REQUEST

Current Zoning: N1-A (neighborhood 1-A) and CG (general Commercial)
Proposed Zoning: N2-B(CD) (neighborhood 2-B, conditional)

Approximately 16.15 acres located at the northeast intersection of Beatties Ford Road and Trinity Road, south of Lakeview Road.

The petition proposes the development of up to 147 duplex, triplex, quadraplex, and multi-family attached dwelling units, including up to 5 live work units. The site is currently wooded and vacant.

TRINITY PARK TOWNHOMES

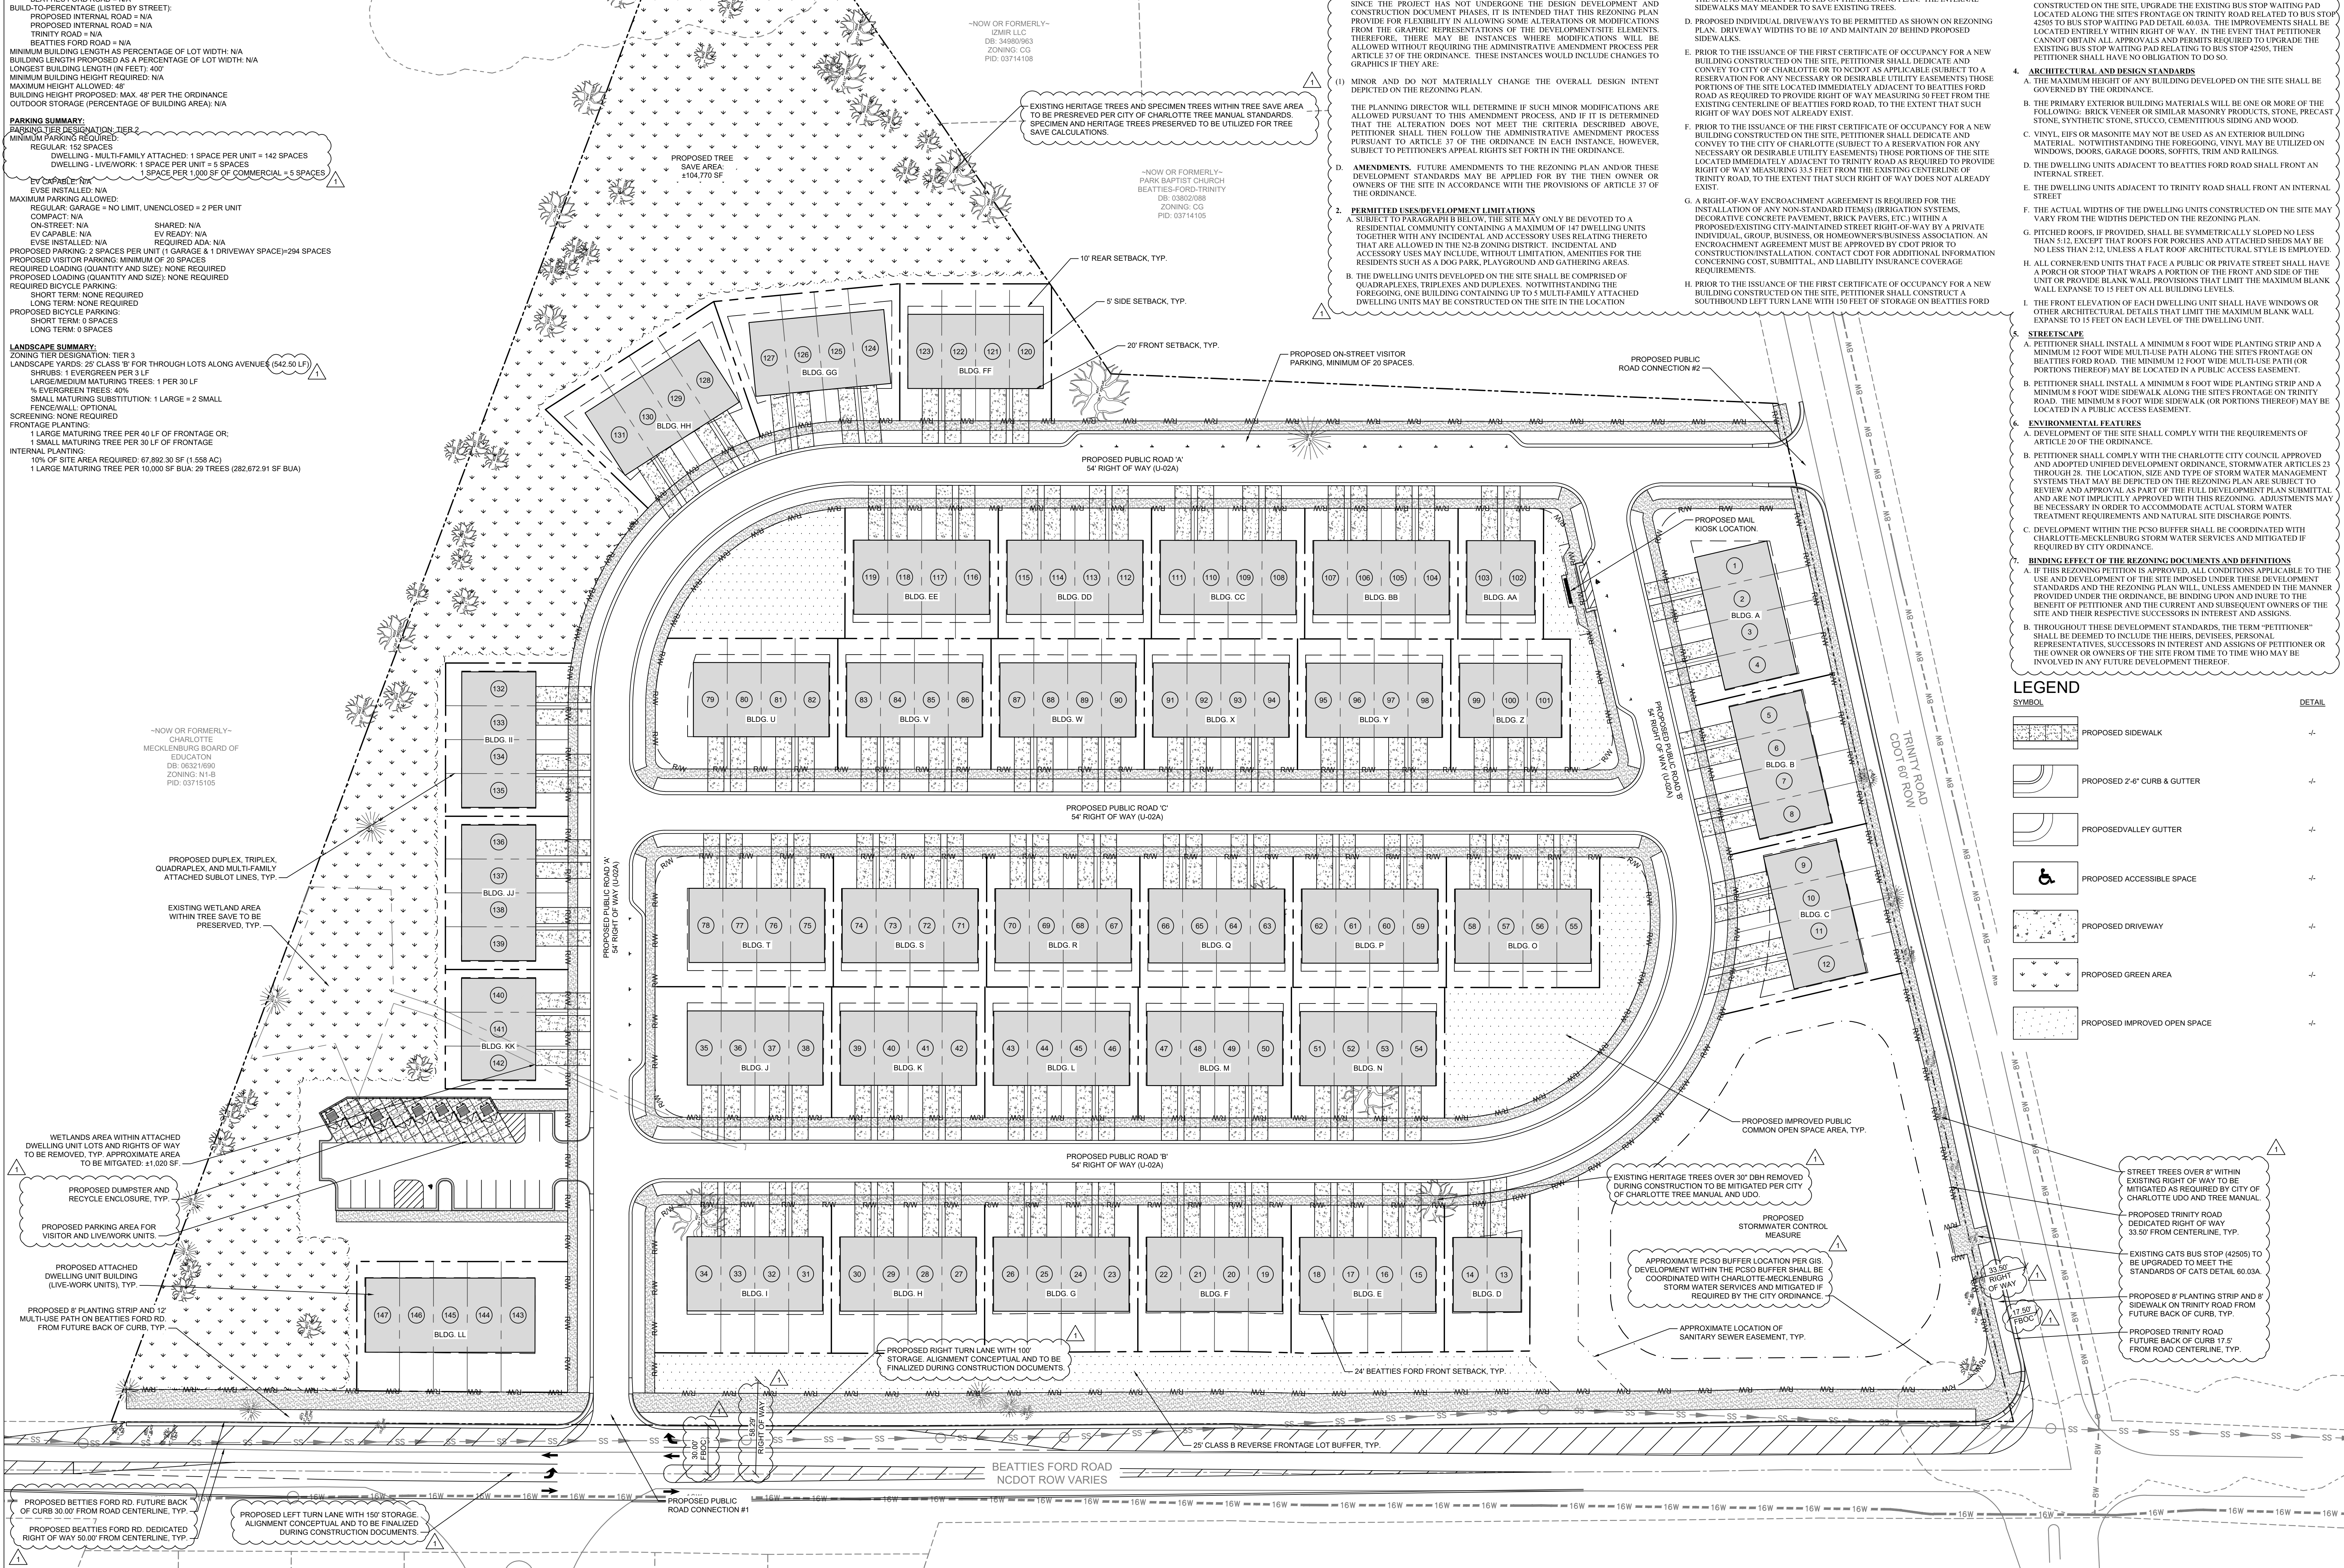
2. ~~Please show sidewalk connecting at the corner of Beatties Ford Rd. and Trinity Rd. Site plan does not clearly show they are connected to either existing or proposed streetscape.~~ **ADDRESSED**

1. ~~Edit conditional note specifying "Dedicated ROW would not apply to Roads A, B, or C. This only applies to ROW along Beatties Ford and Trinity Rds."~~ **ADDRESSED**

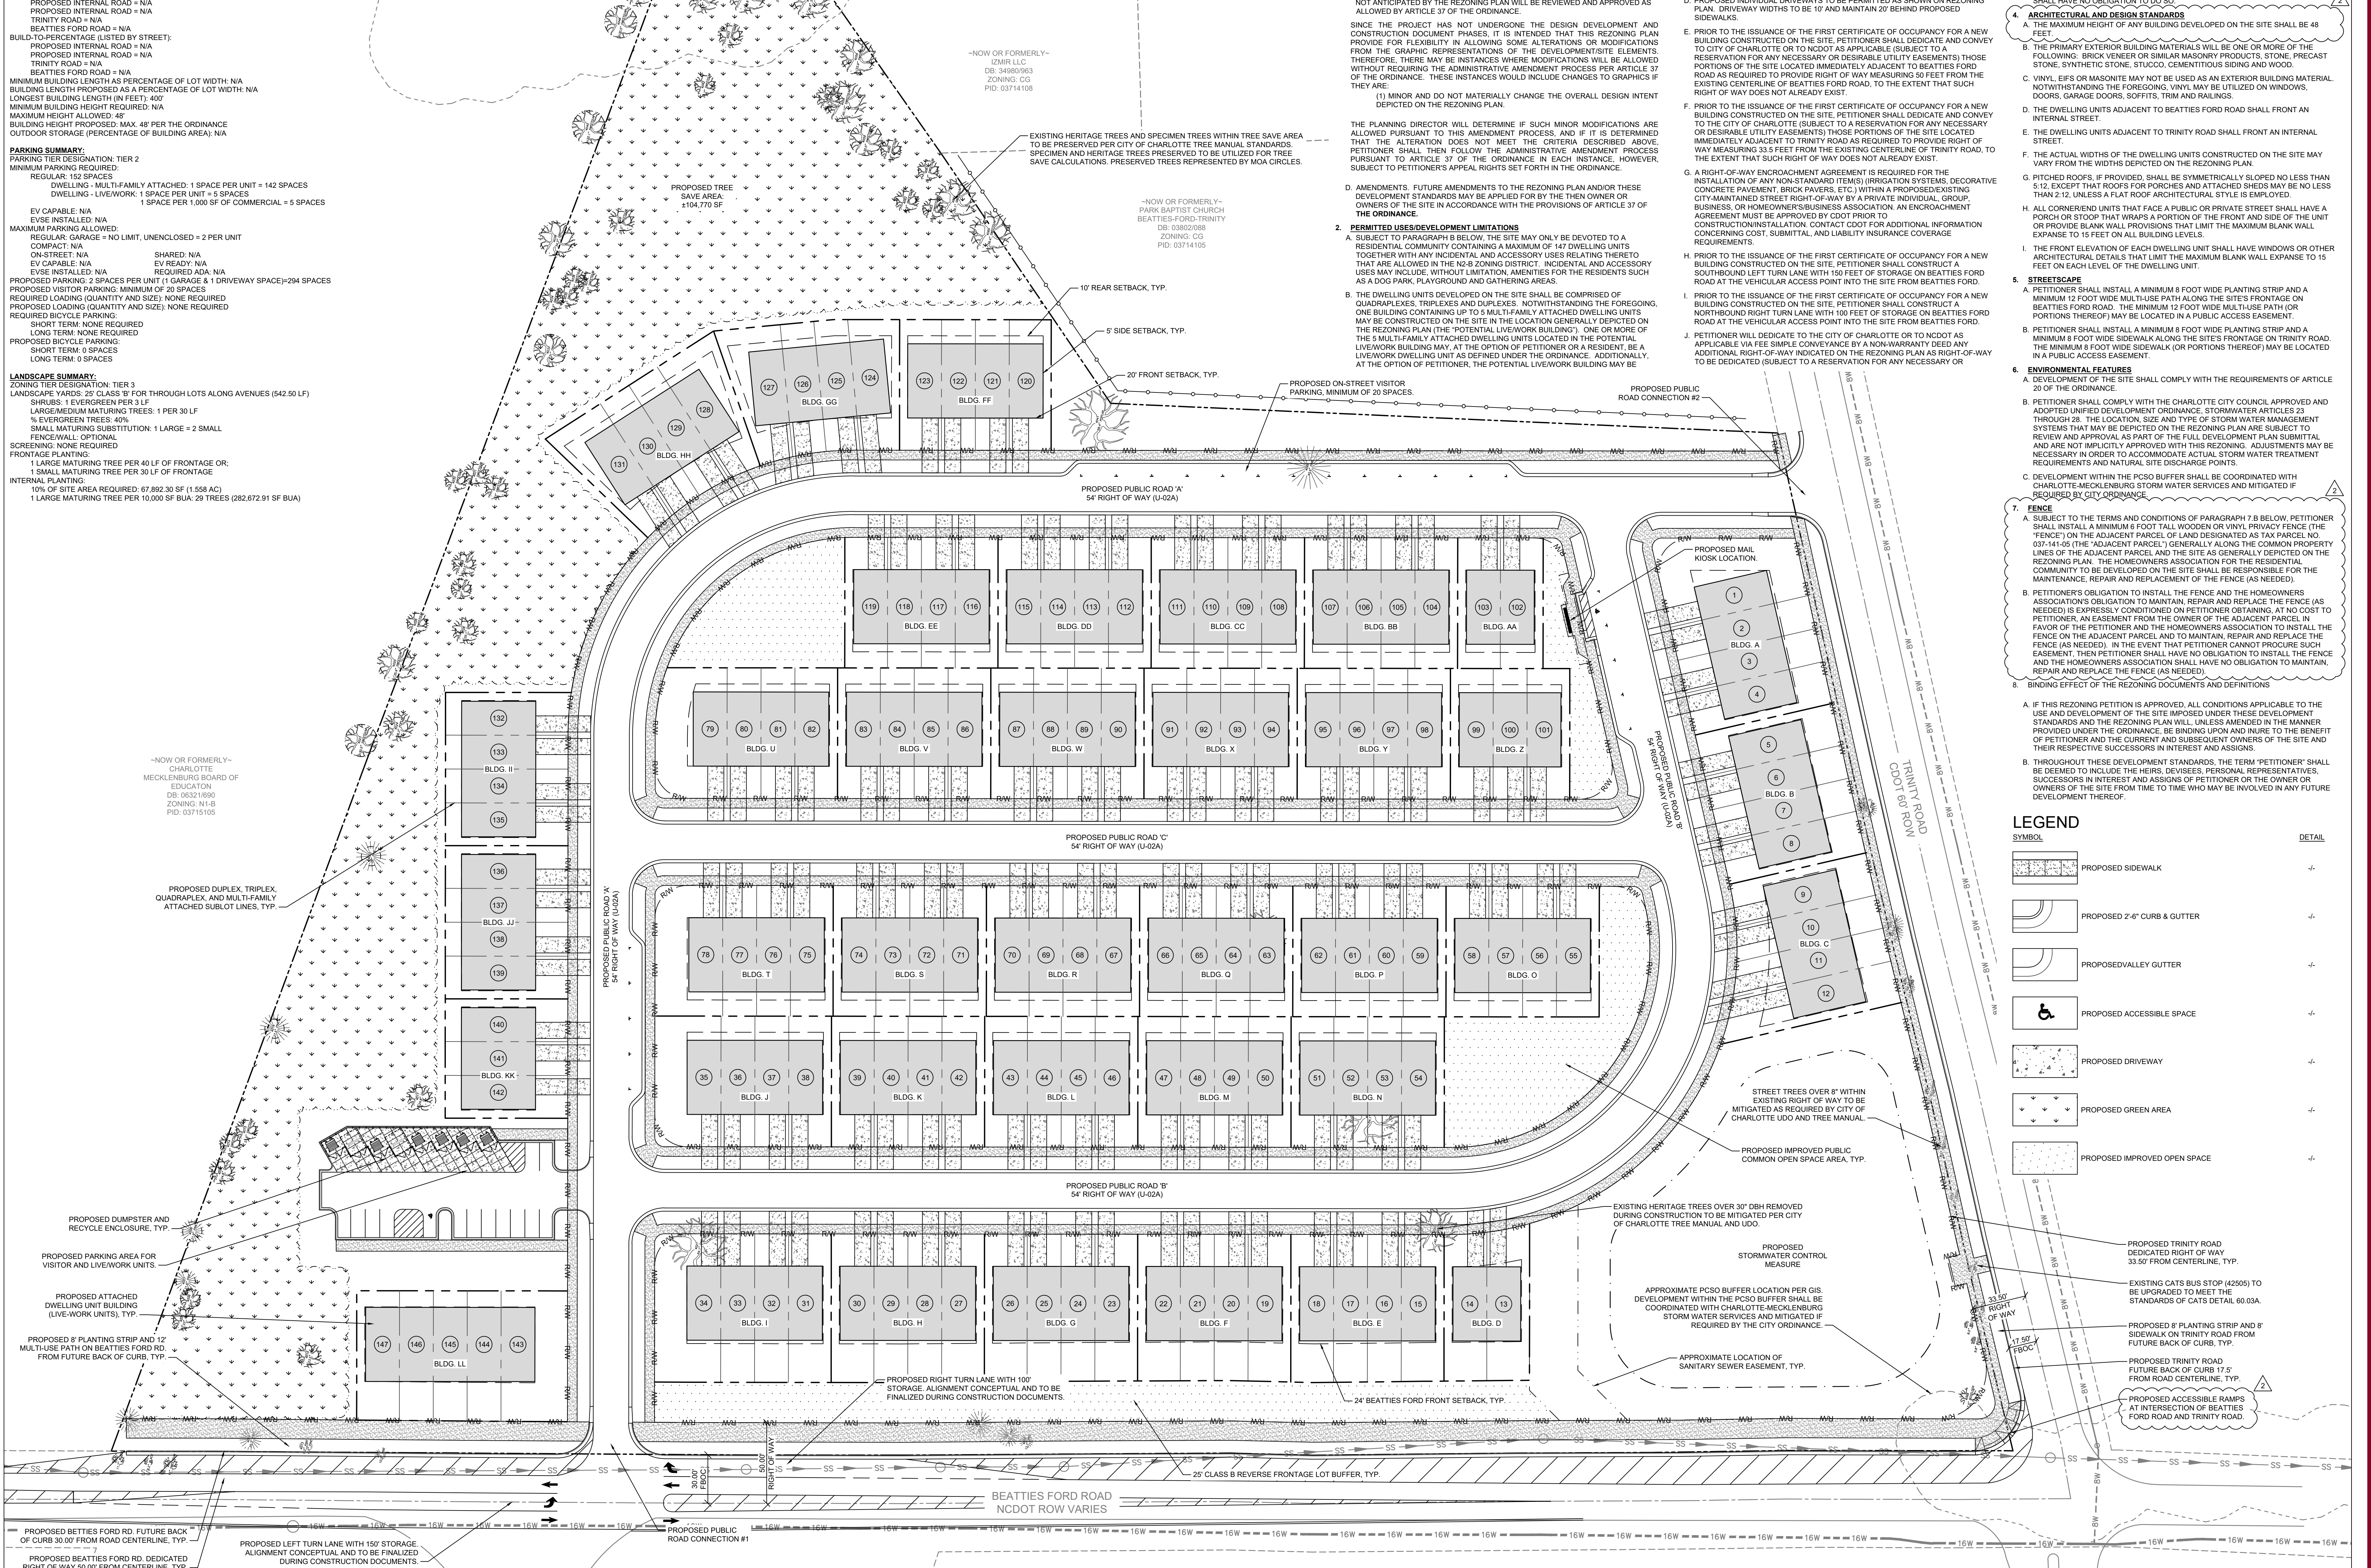
3. ~~CTR commitments were removed from table. Please update table to match previous site plan submittal from February 2024.~~ **ADDRESSED**
